Further Tree Officer Comments

AL/27/20/PL - LLD1680 - Hook Lane, Aldingbourne

Proposed Block Plan 1:500@A3

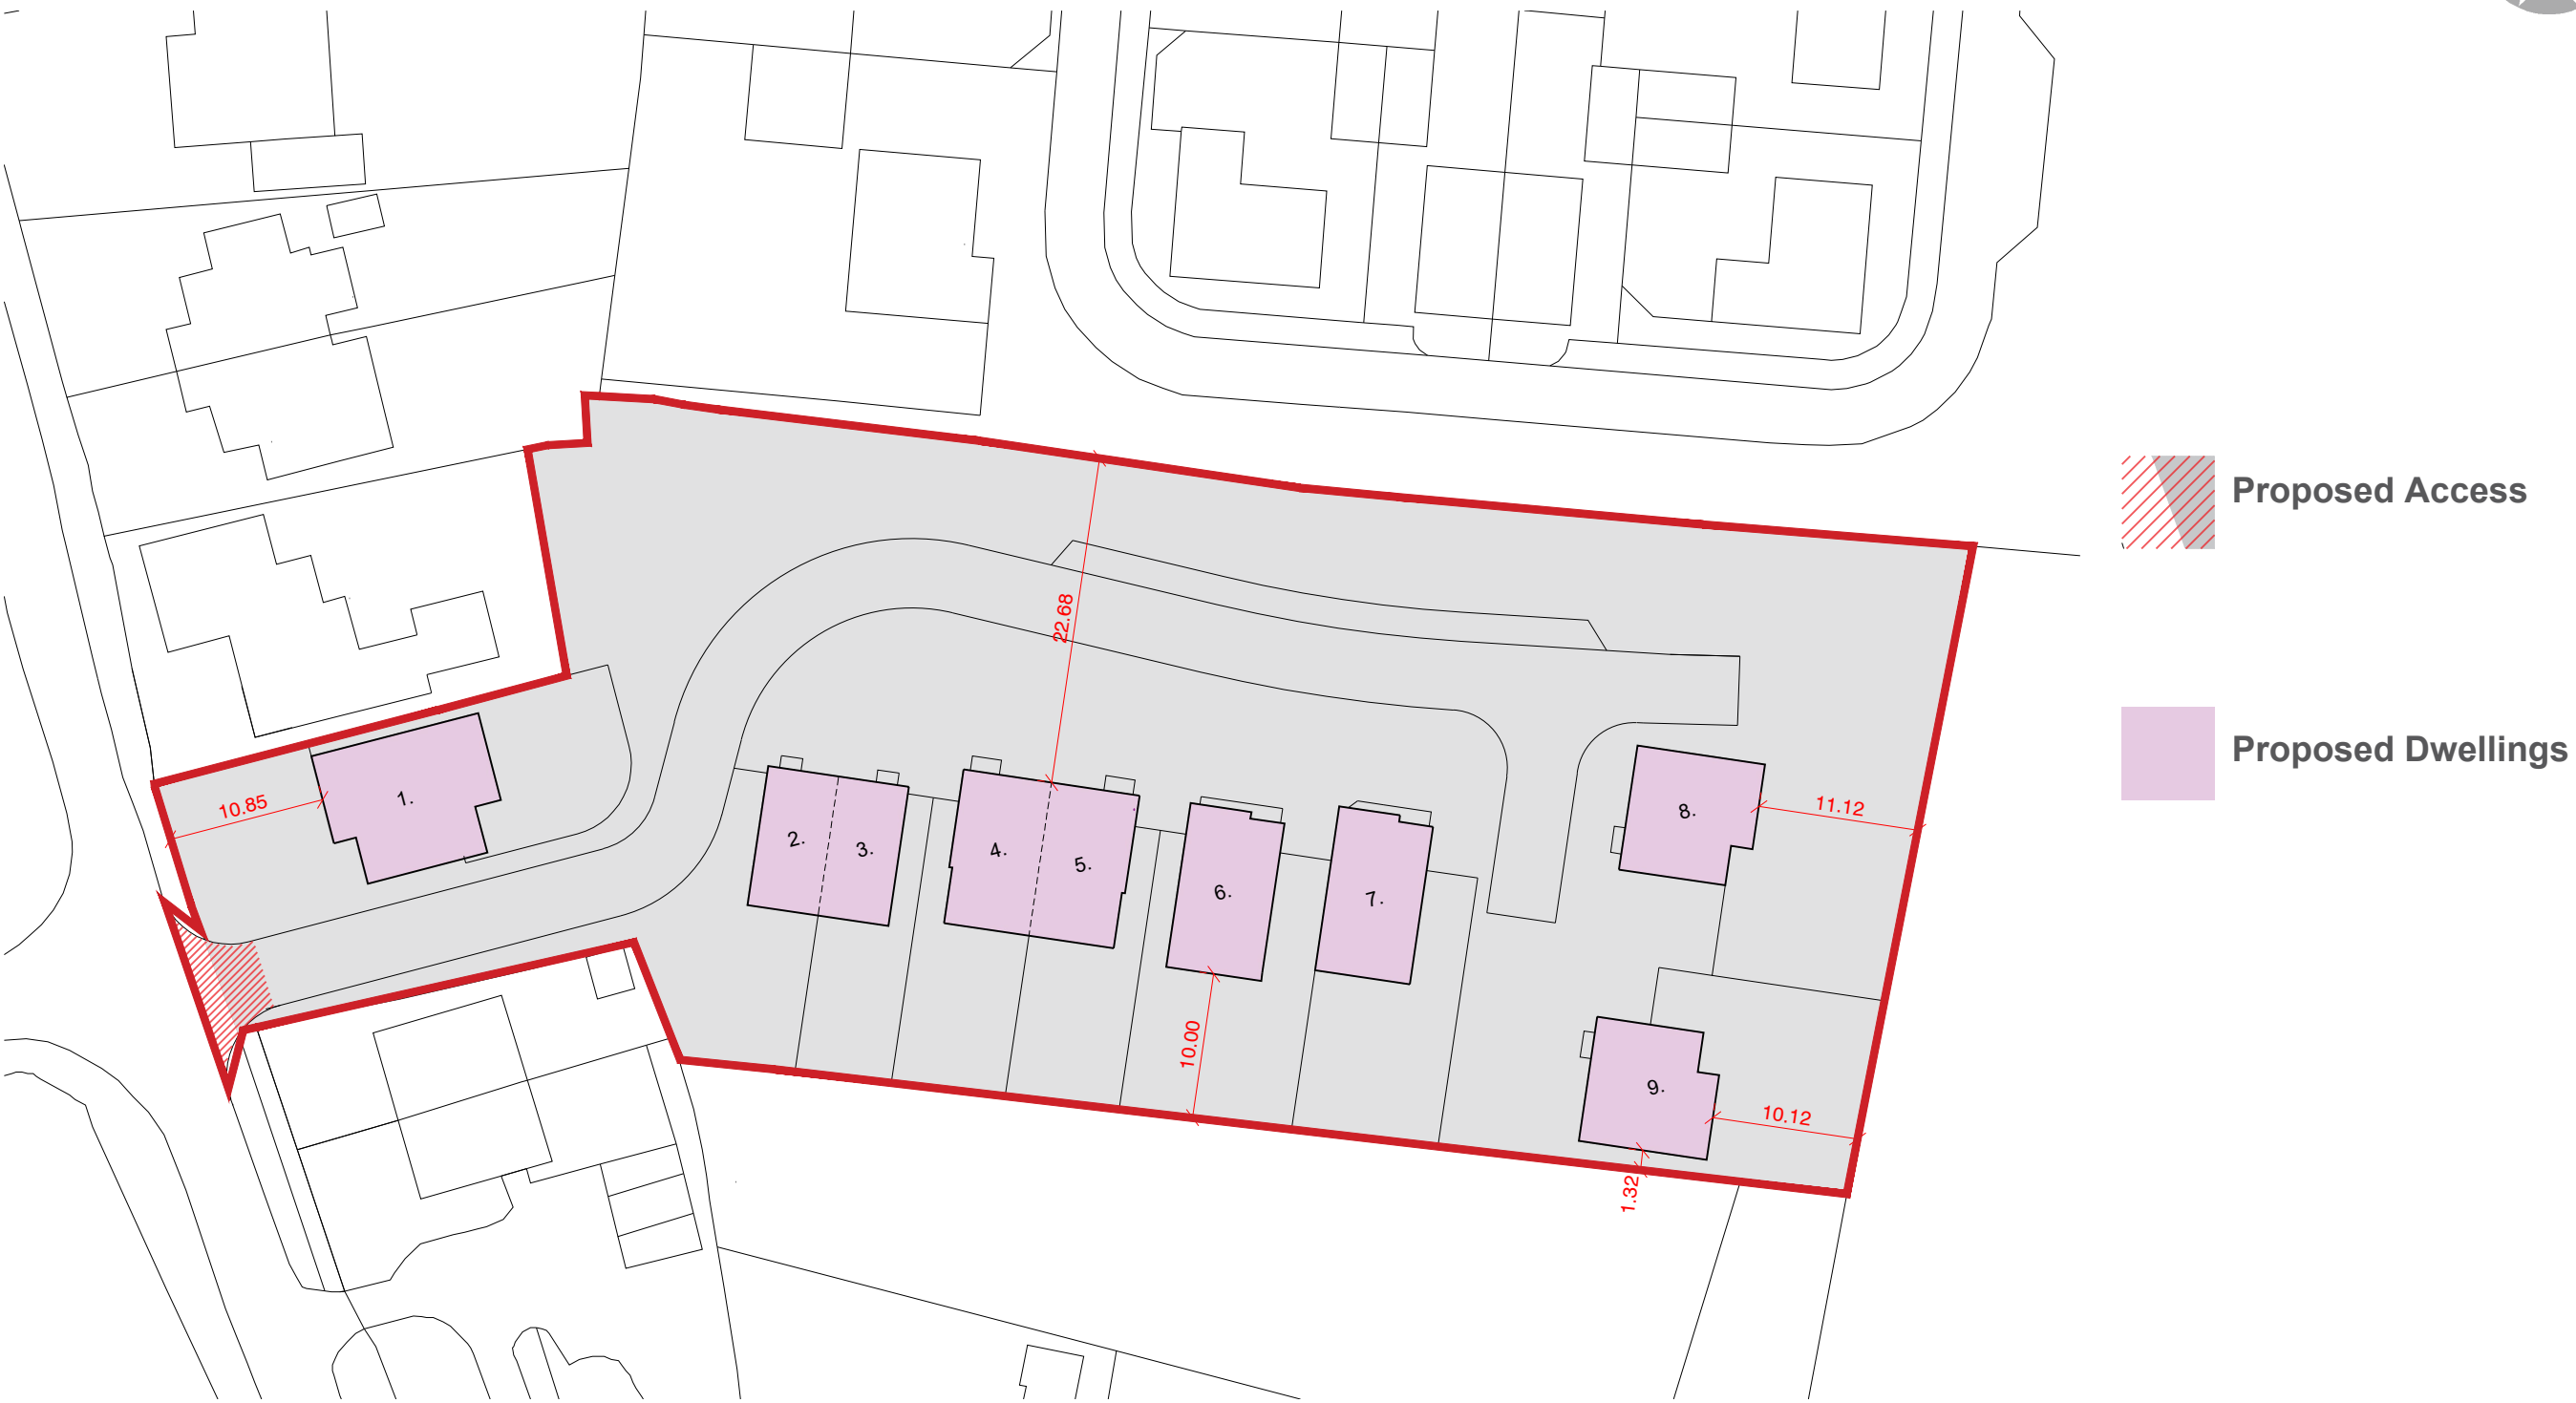
1. The British Standard (BS 7.4.2.3)(extract below) confirms that hard standing should not account for any more than 20% of any existing unsurfaced ground within the RPA. The current plans comply with the BS - please refer to the email below from Lizard Landscape. So whilst it may not be the most desirable solution

for the Council's Tree Officer it does offer a feasible and acceptable solution, and importantly one that would ensure the trees along the northern boundary are retained and protected and will continue to contribute to local amenity. Understood and I acknowledge that such a limitation can theoretically ensure trees are retained and protected – although not necessarily to adequate levels (subjective). The Standard imposes a limitation, it does not recommend RPA incursion. I would draw your attention to that part of the Standard which discusses 'overriding justification' for the intrusion into retained tree RPAs and also reassert the inherent risk associated with such an ambitious use of 'No-dig' construction. Furthermore, such ambitious use of 'No-dig' is rarely seen or evidenced to have been installed as per approved plans and methodology, in my own experience. Although every application must be judged on its merits, I strongly believe that 'No-dig' construction should not be considered a default position within any development proposal; rather as an engineered solution where RPA incursion is justified and where no realistic alternative to layout exists.

2. The project team has given Mark Warwick's comments on design careful consideration, and whilst we note and acknowledge an element of risk associated with no dig construction if the trees on the northern boundary are worthy of retention we believe they should remain outside any domestic curtilage where they can be managed and maintained in perpetuity, as Mark advised on the refused scheme, the position of trees within gardens can result in pressure to reduce the size of the trees or in some case remove the trees from the garden area. These comments were taken on board and have informed the revised layout design to retain and protect the tree line along the northern boundary. Those trees could be captured within domestic curtilage without being subject to residential pressure to prune or remove, provided those gardens are of sufficient extent so as not to create an unacceptable level of risk to occupiers (perceived or otherwise).

3. Furthermore, whilst we consider the trees on the northern boundary to be of moderate quality, we accept they offer a visual screen for houses north of the site. To enhance this border further we propose additional planting within a landscape buffer – please refer to the attached ecology enhancement scheme. A welcome intention, although we have yet to see any detail around soft landscape proposals (species, precise locations, size at time of planting, spacing, etc.) to be satisfied any long-term enhancement/continuity of the verdant character of the northern boundary will occur post-development. The Ecology Enhancement Plan is a one-page illustrative drawing. Have all the documents been uploaded?

4. The attached drainage plan demonstrates that the site's drainage system, including the surface water storage tank can be provided in locations outside of ground protection and no dig zones and will not impact the RPAs of the retained trees. It certainly looks to be the case, although unfortunately the RPA of off-site oak (T23) is not shown on the following drainage strategy plan. Furthermore, we should seek confirmation within any approved Drainage Strategy/Statement that directional drilling technique (working from outside RPAs) is employed when connecting (S10?) to ditch outfall (refer Engineering details drainage strategy 01 Rev B).
